Appeal Decision

Appeal Ref: APP/R5510/W/23/3327272

170 Harefield Road, Uxbridge UB8 1PP

PROPOSED SITE SECTION C-C  
1 : 200

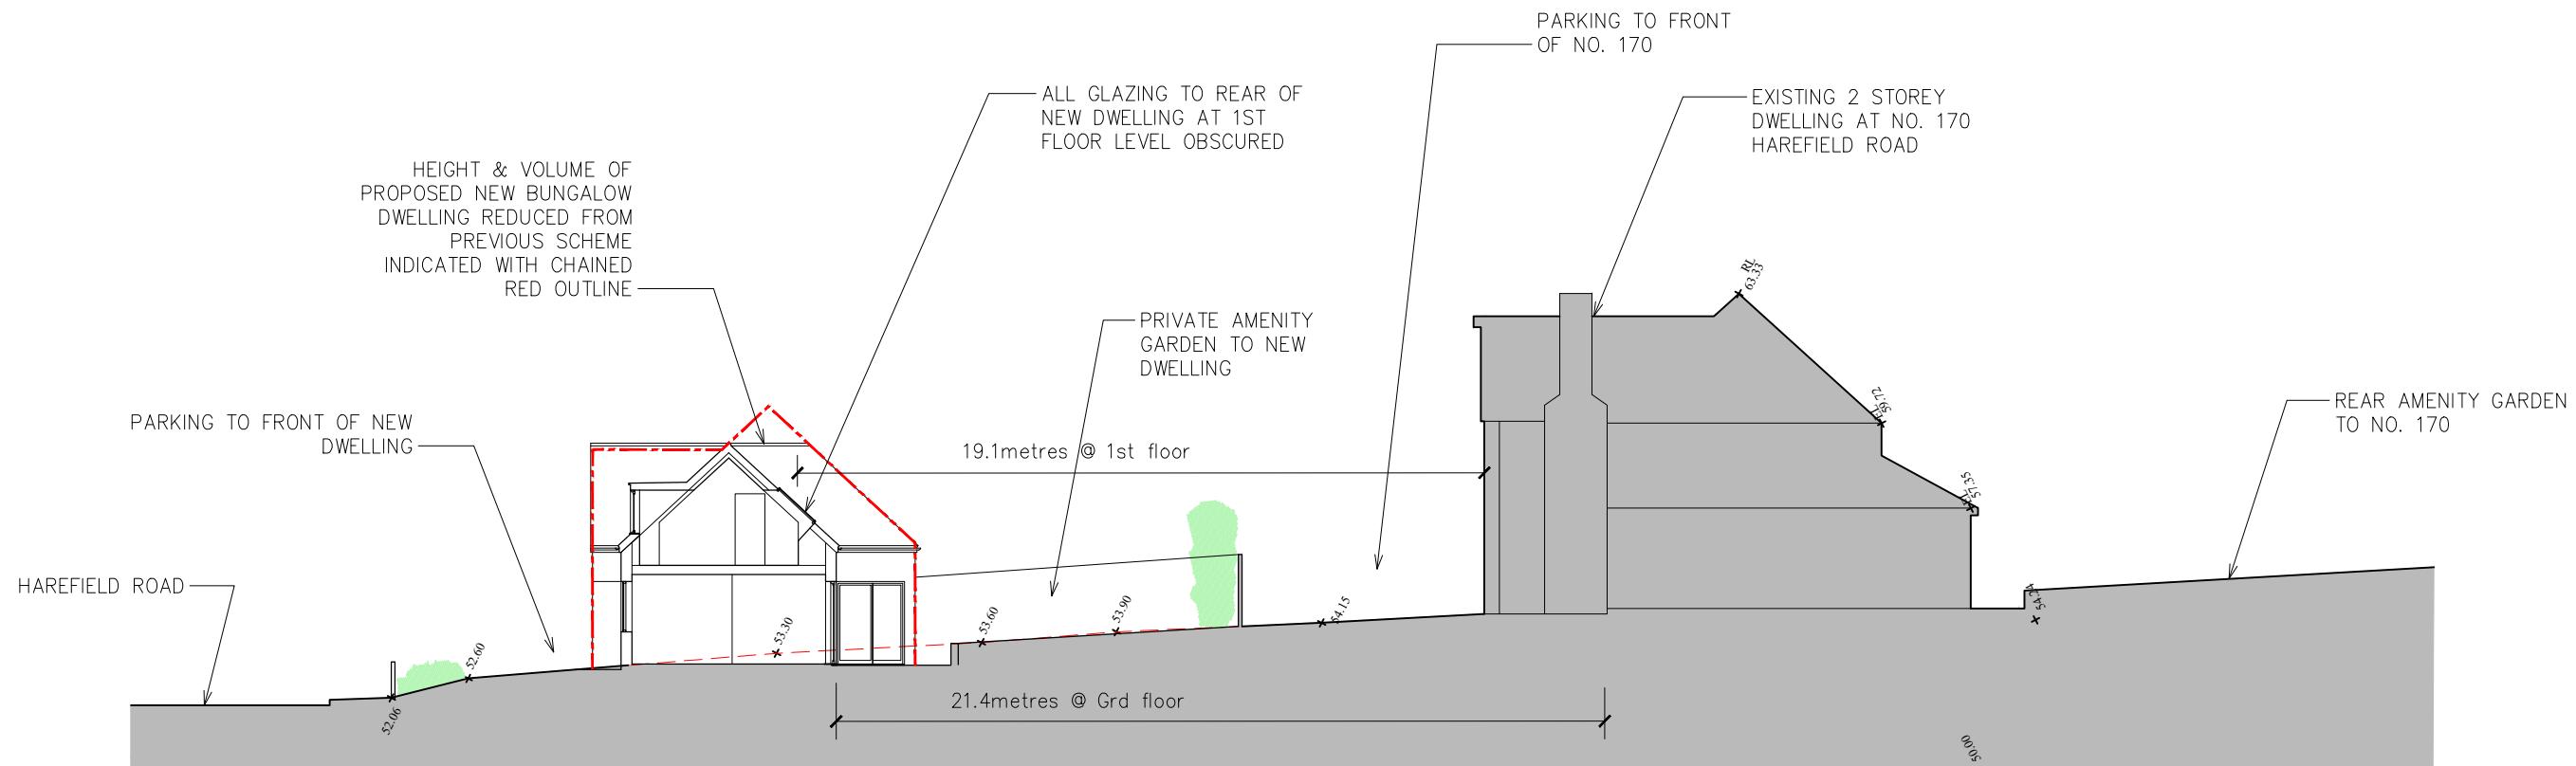
9. A cross section across between the road and Nos. 170 and 172 has been provided by the appellant to illustrate the change in ground levels across the site which was also observed during the site visit. The proposed bungalow would be sited at a lower ground level than this pair of semi-detached dwellings which, although sited well back from the road, do make a positive visual contribution to the character and appearance of the streetscene.

10. By reason of siting and height, the proposed development would obscure some views of Nos. 170 and 172 but the upper floors would still be visible. There would be views of these dwellings available across the garden of No. 168. Although there would be an effect on some views towards these dwellings this matter alone would not be a reason for this appeal to fail only adds in a limited way to the unacceptable harm which has been identified.

DRAWING TITLE
PROPOSED GROUND &
FIRST FLOOR PLANS

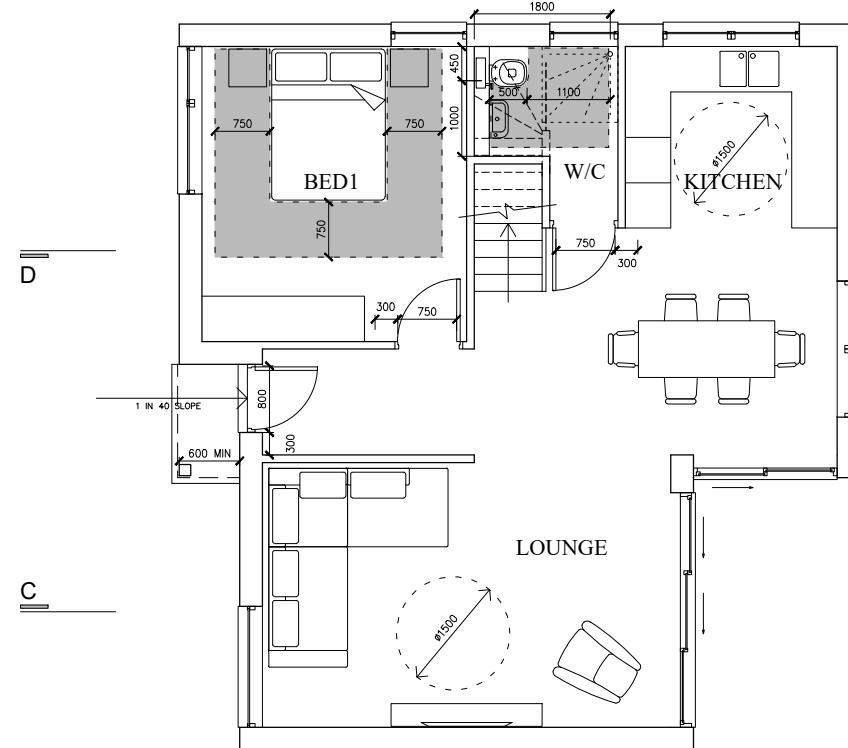
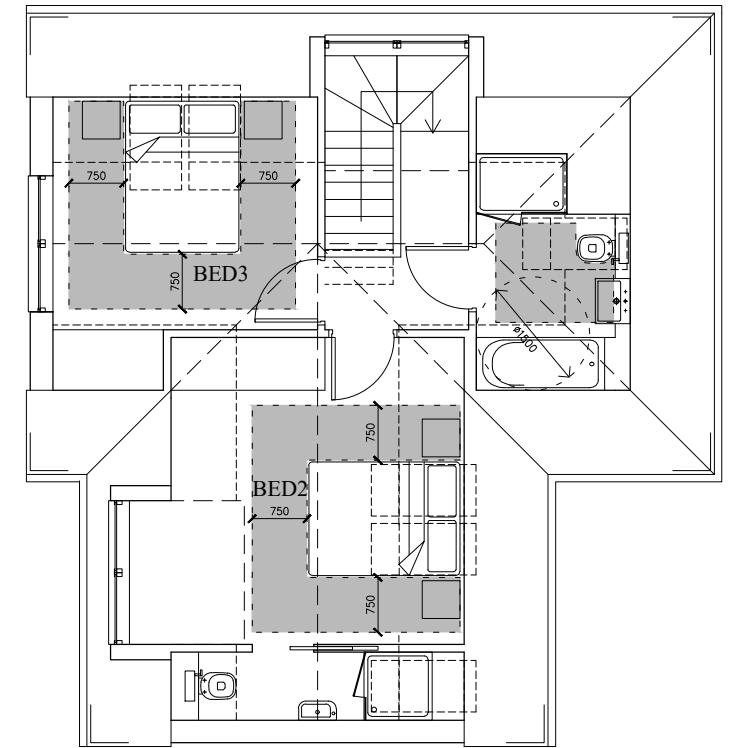
13. The design of No. 170 is such that the front elevation includes a 2-storey bay with windows which have the appearance of serving habitable rooms. There is a further window above the front door. The separation distance claimed by the appellant between the ground floor habitable room windows of the proposed bungalow and No. 170 would be just over the 21 metres. However, the measurement point provided on the cross section (Drawing No 112/D) does not appear to be aligned with the ground floor bay window of No. 170. From what could be observed the separation distance, even measured at an angle, would appear to be closer to the circa 18 metres referred to by the Council. The first floor bay window of No. 170 would be some 19 metres from the rear roofslope of the proposed bungalow. No separation distance between the site's rear boundary and the front elevation of No. 170 is provided in the evidence but it appears to be no more than around 7 metres.

14. By reason of the sloping land and the screening effect of the fencing along the rear boundary of the site (which could be retained and maintained by a suitable condition), any outlook from or towards the ground floor windows of No. 170 and the proposed bungalow would be limited. However, there would still be a potential outlook from the garden and the lounge window of the proposed bungalow towards the first floor bay window of No. 170 and, to a lesser degree, No. 172. For the occupiers of Nos 170 an 172 there would at least be the impression of overlooking from the proposed development and an associated loss of privacy.

15. Further, although some overlooking in urban areas can be expected, such as that which may exist for some of the surrounding properties as referred to by the appellant, there would be a clear outlook from the first floor windows of Nos. 170 and 172 towards the rear garden of the proposed bungalow. There would also be an outlook from No. 170 towards the proposed large rear lounge window. Accordingly, because of overlooking from the first floor windows there would be a lack of privacy for the future occupiers of the proposed development and this would adversely affect their living standards.

LOCATION	Land to the Front of 170 Harefield Rd Uxbridge UB8 1PP	
DRAWING TITLE	PROPOSED ELEVATIONS	
DATE	Dec 2021	
SCALE	1:100 @A3	
JOB NO	2009	115/D
DWG NO/REV	115/D

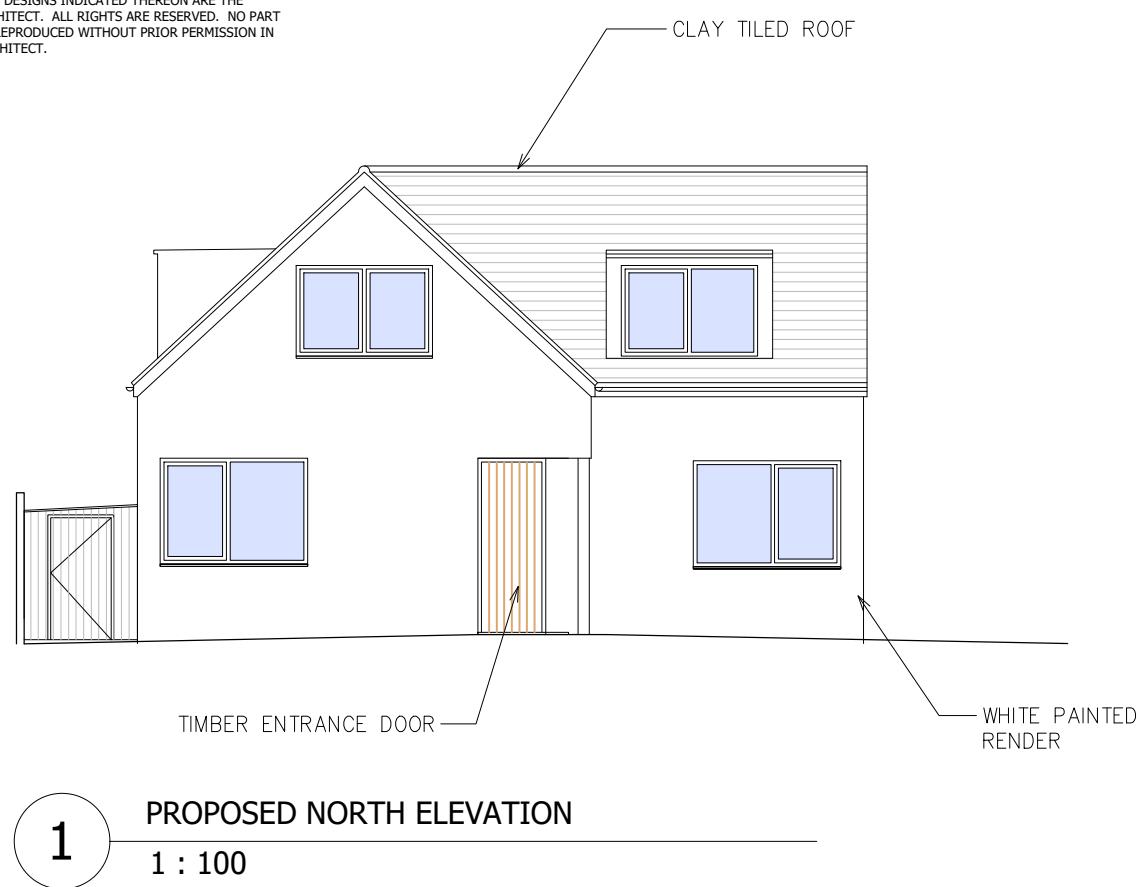
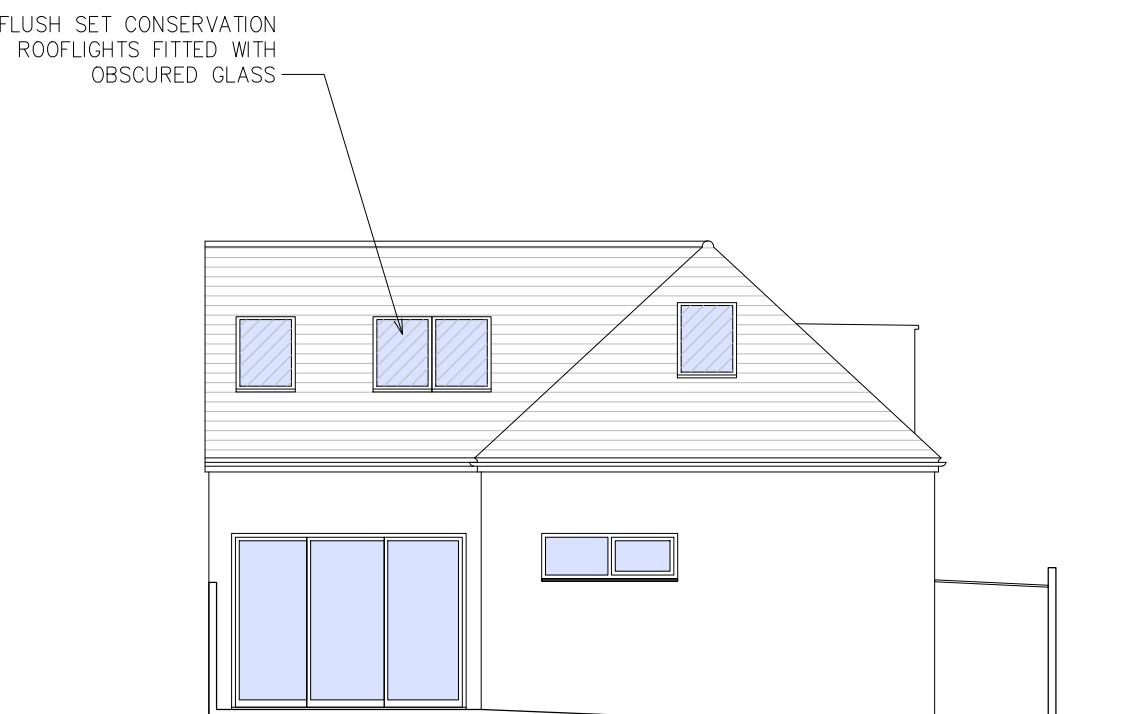
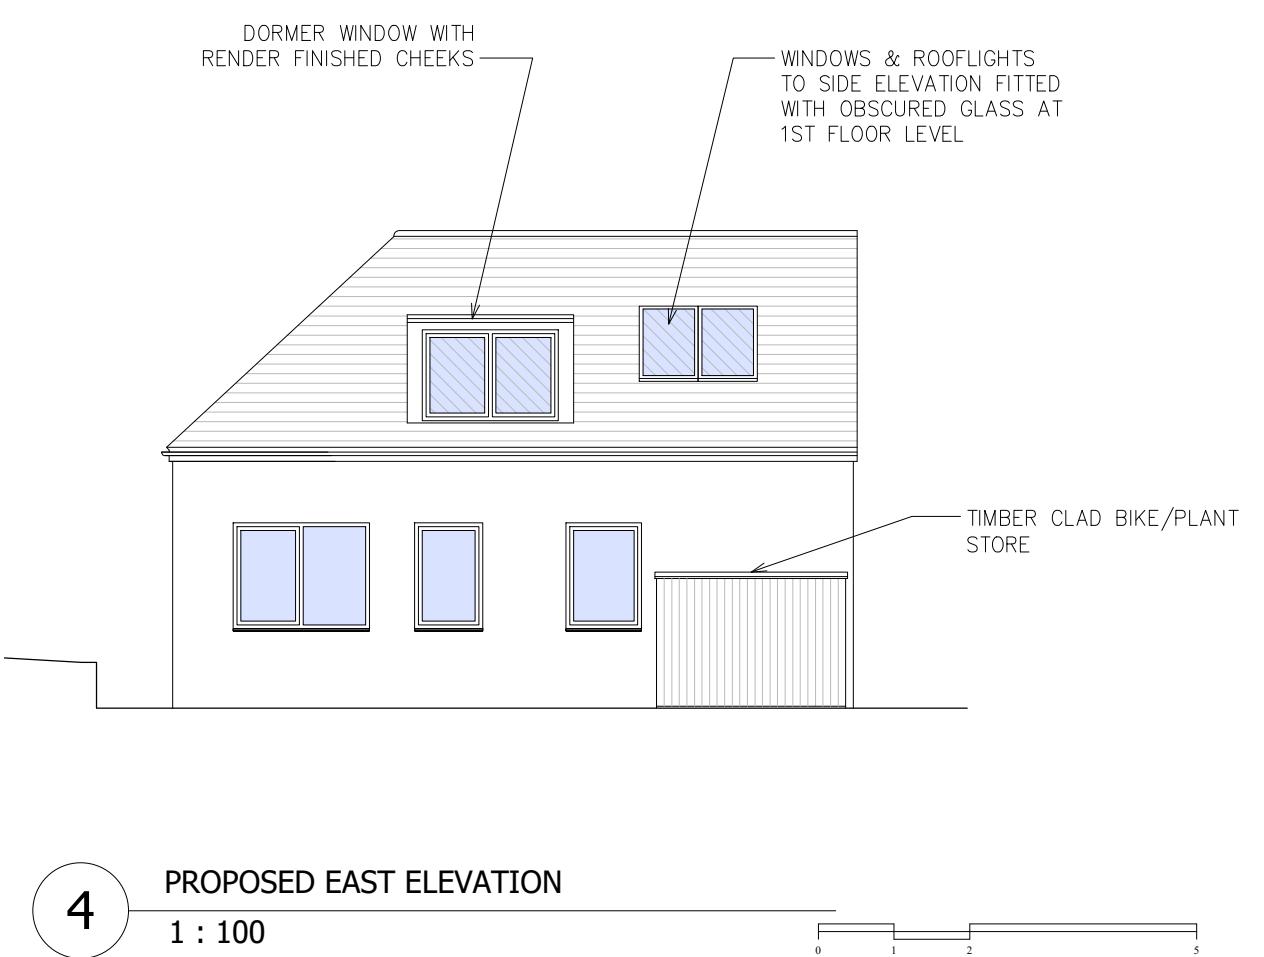
8. However, the size of the appeal site would be amongst the smallest residential plots along this part of Harefield Road and, although reduced in scale from the previous proposal, the appeal scheme would appear a cramped form of development when viewed from the road. The side elevations of the proposed bungalow would be sited close to the boundaries with the access. Although satisfying the required standard, the private amenity space would be of a modest size when compared to other gardens. For these reasons, the proposed development would fail to respect the spacious and verdant character and appearance of the surrounding area and this unacceptable harm is accentuated by the bungalow's prominent siting within the streetscene. The development density of the appeal scheme claimed by the appellant does not alter this assessment.

12. When compared to the previous scheme, the evidence indicates. that there is a greater separation distance between the front elevations of Nos 170 and 172 and the rear elevation of the proposed bungalow. Other than a large window serving the lounge, the other openings within the proposed rear elevation and roof could be obscurely glazed with limited openings that could be secured by a suitable condition.
